## REQUEST

Proposed Zoning: MUDD-O (mixed-use development district, optional) and MUDD-O SPA (mixed-use development district, optional, site plan amendment) with 5-years vested rights.

Approximately 45.67 acres located on the west side of South Tryon Street, north side of Clanton Road, and east side of Interstate 77.

## SUMMARY OF PETITION

A ST. VARDELL LN. SECTION WITHOUT ON-STREET PARKING 3/16" = 1'-0"

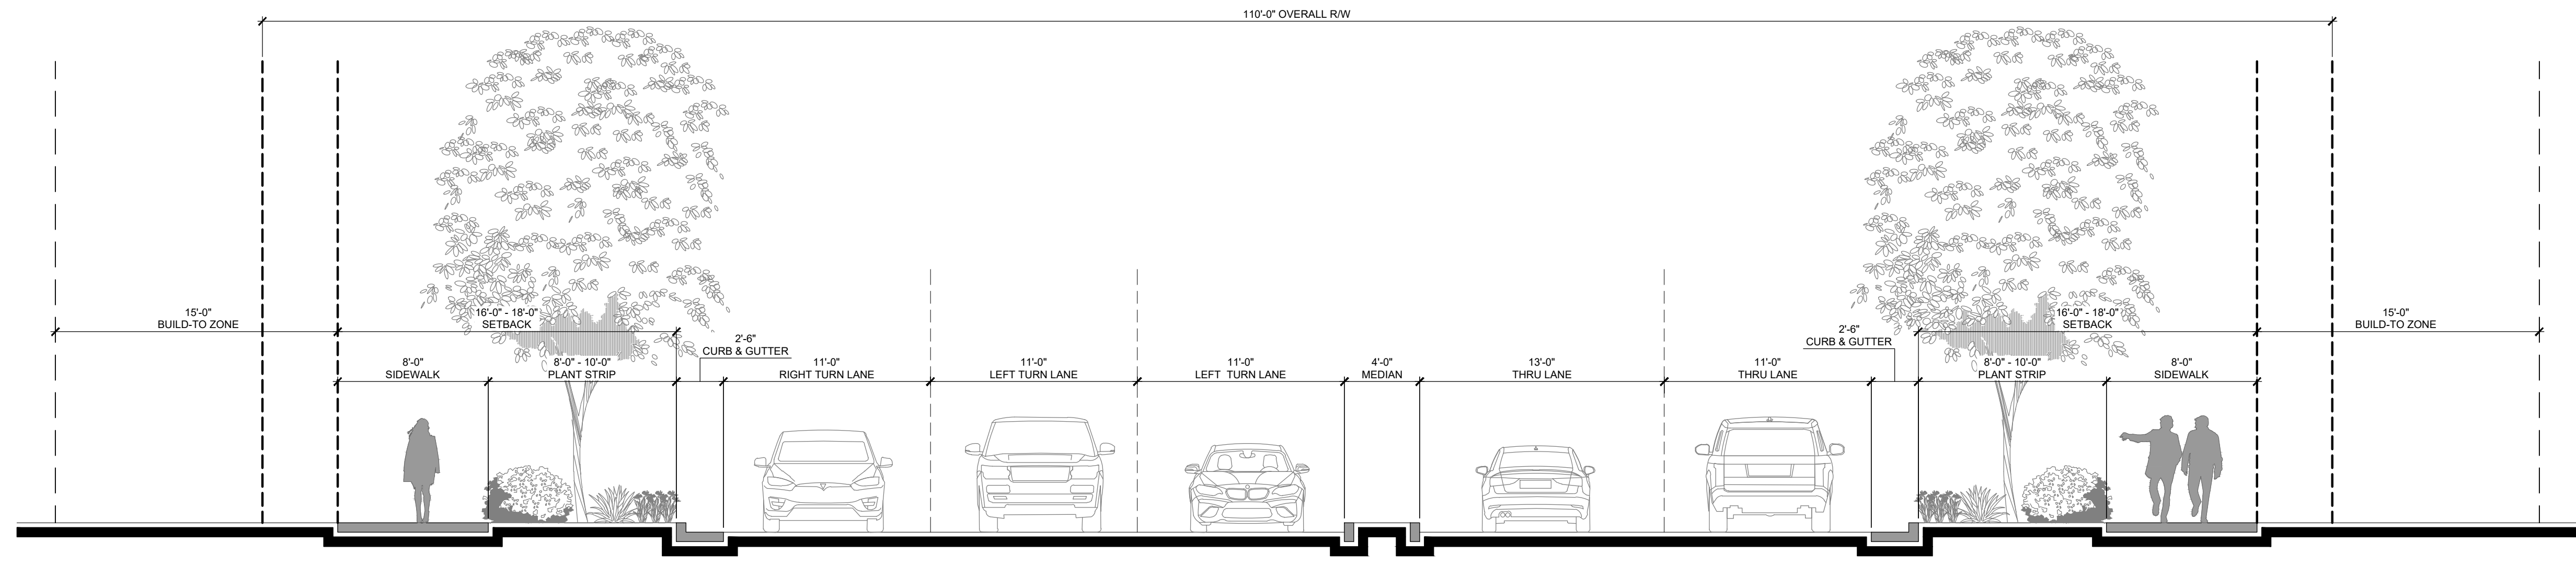
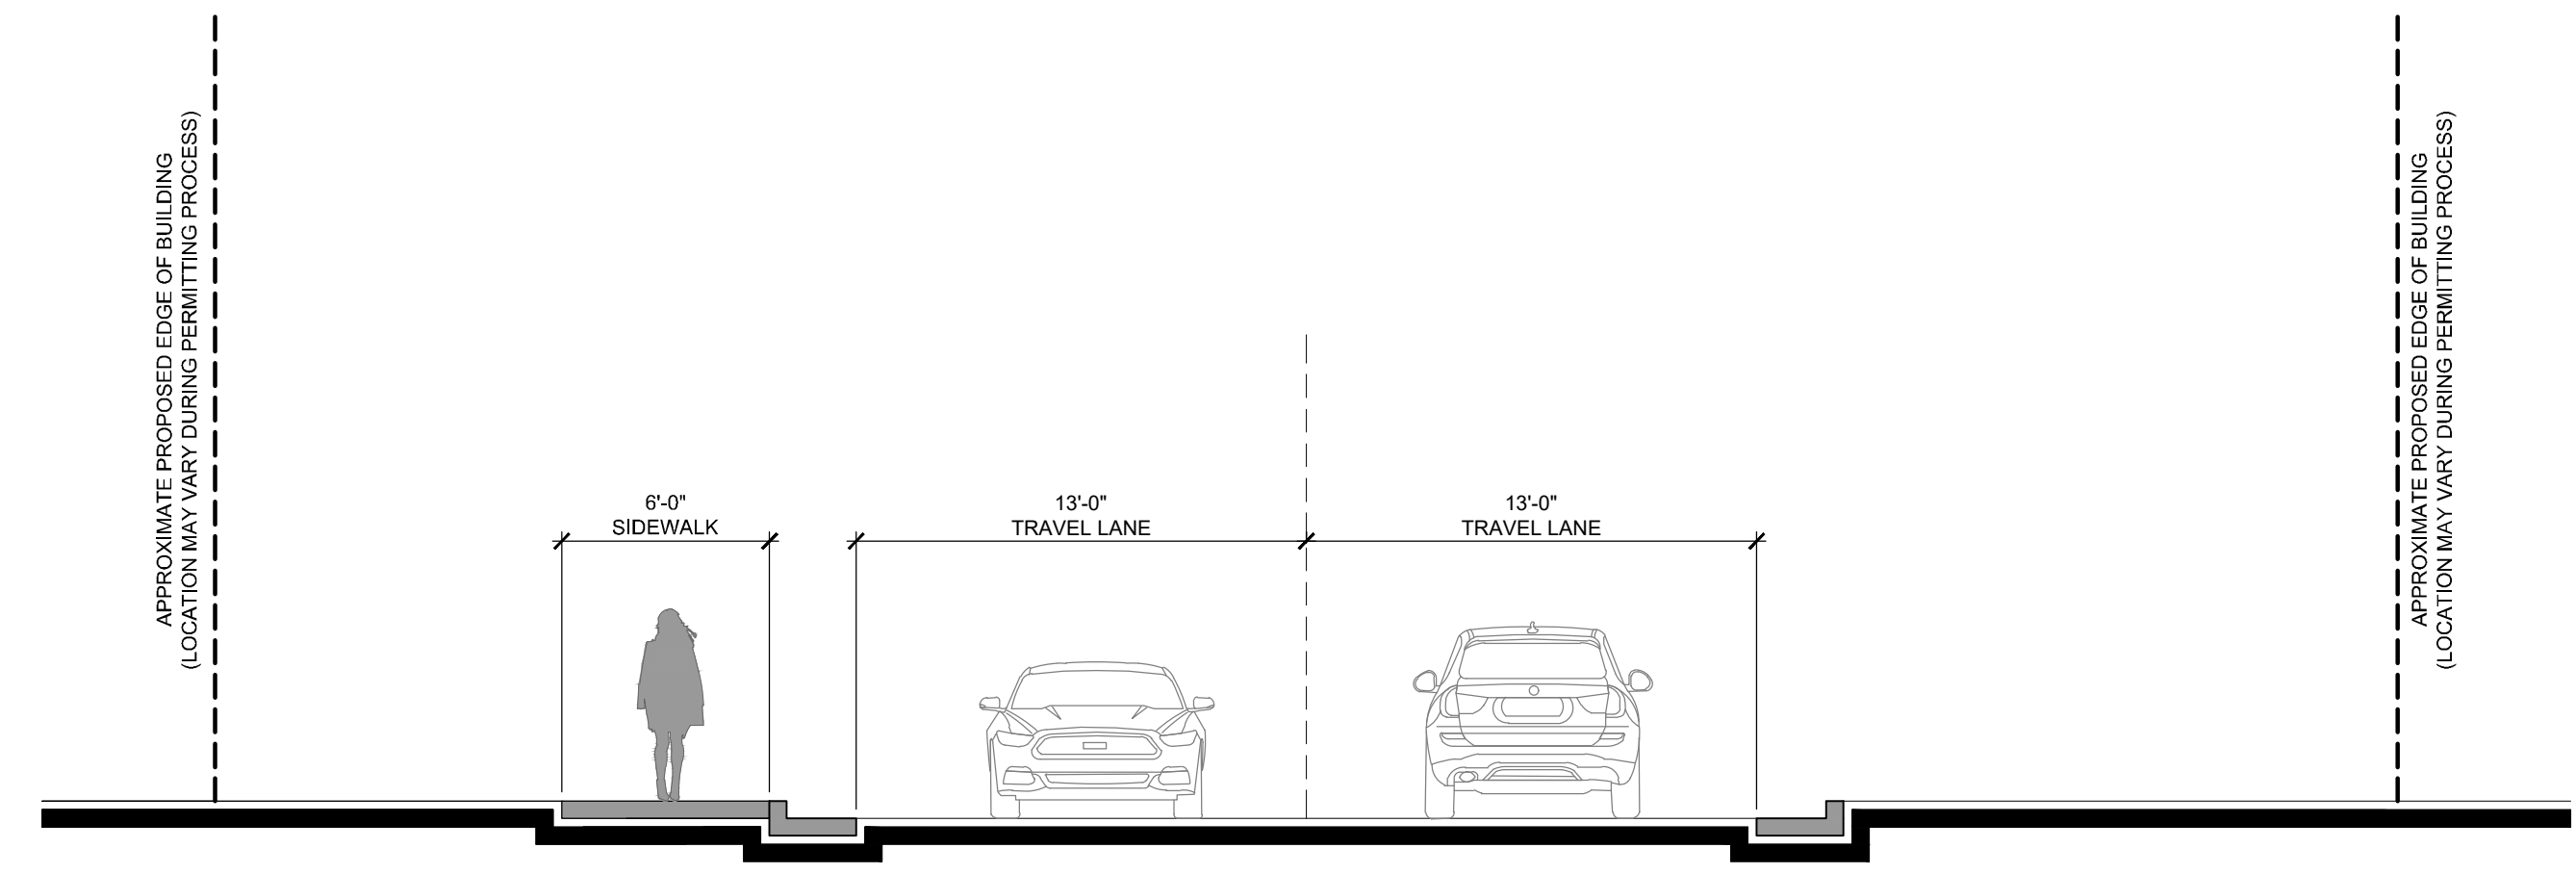
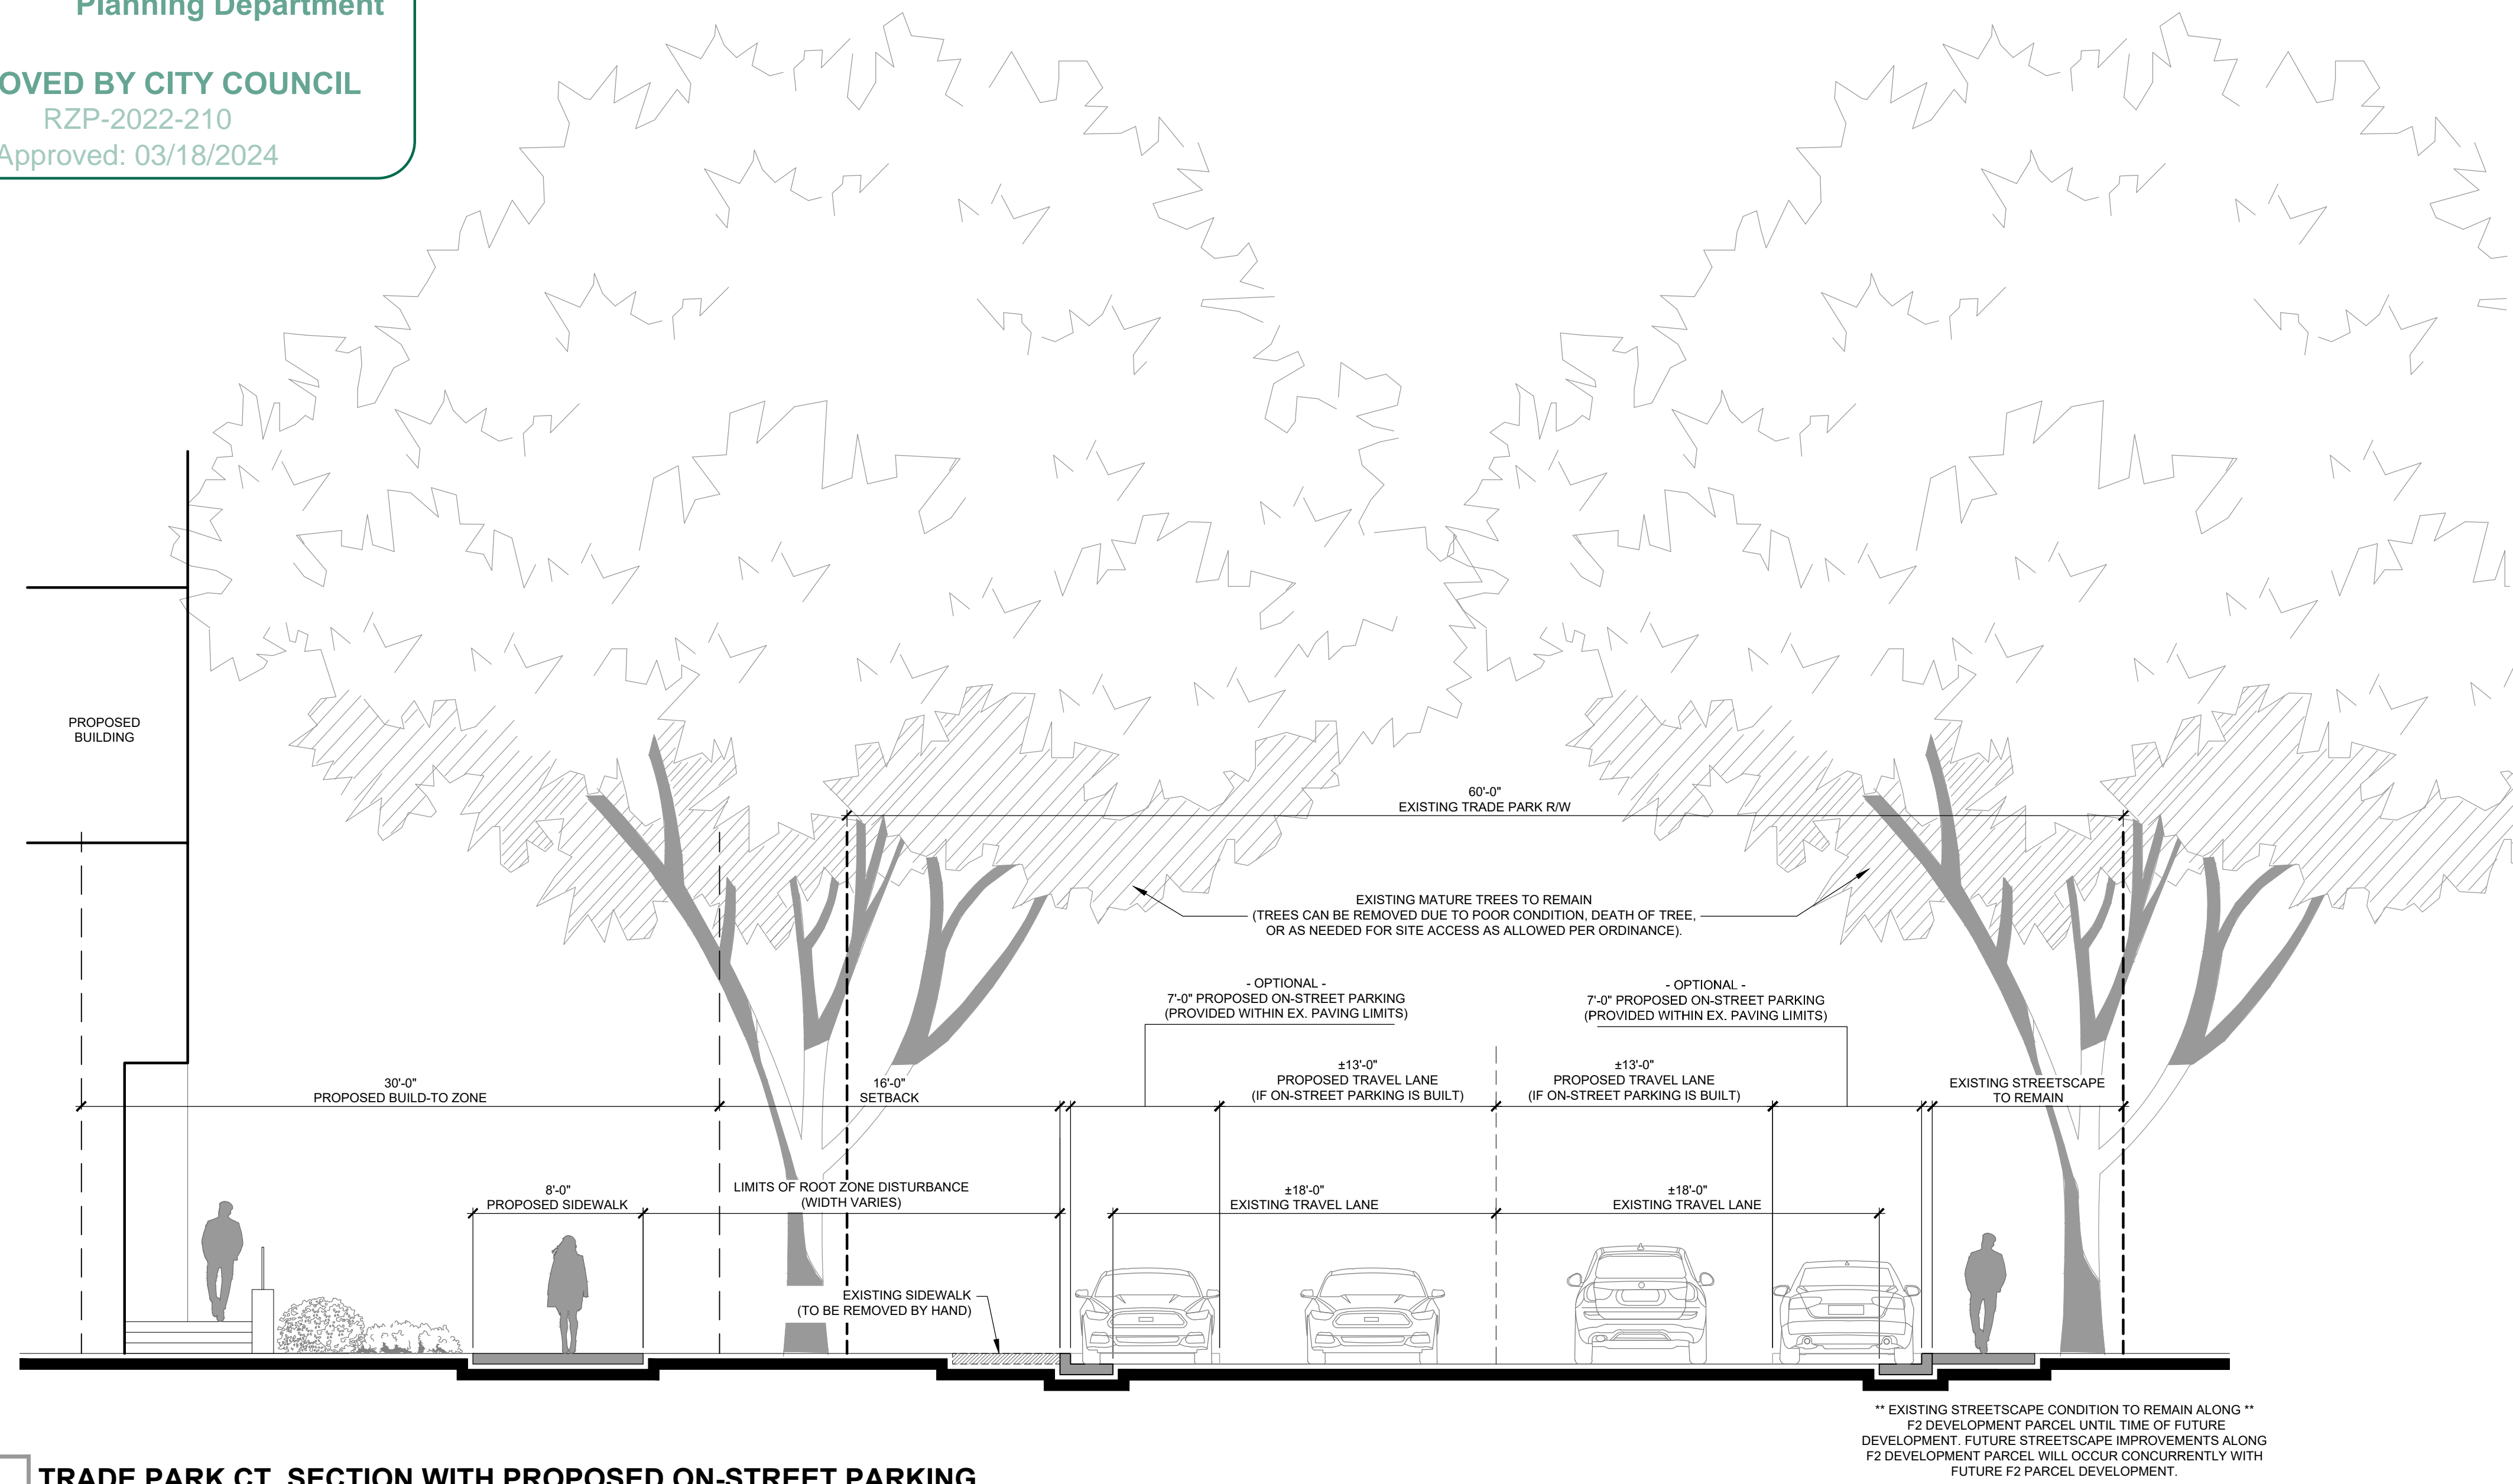
9. In note 6 of the optional provisions add the word "reasonable" after the word "allow" in the first sentence.
10. In note 5 of the General Transportation and Streetscape notes add "as approved by CDOT and NCDOT" at the end of the note.
11. Fill in the referenced date of the approved TIS throughout the conditional notes.
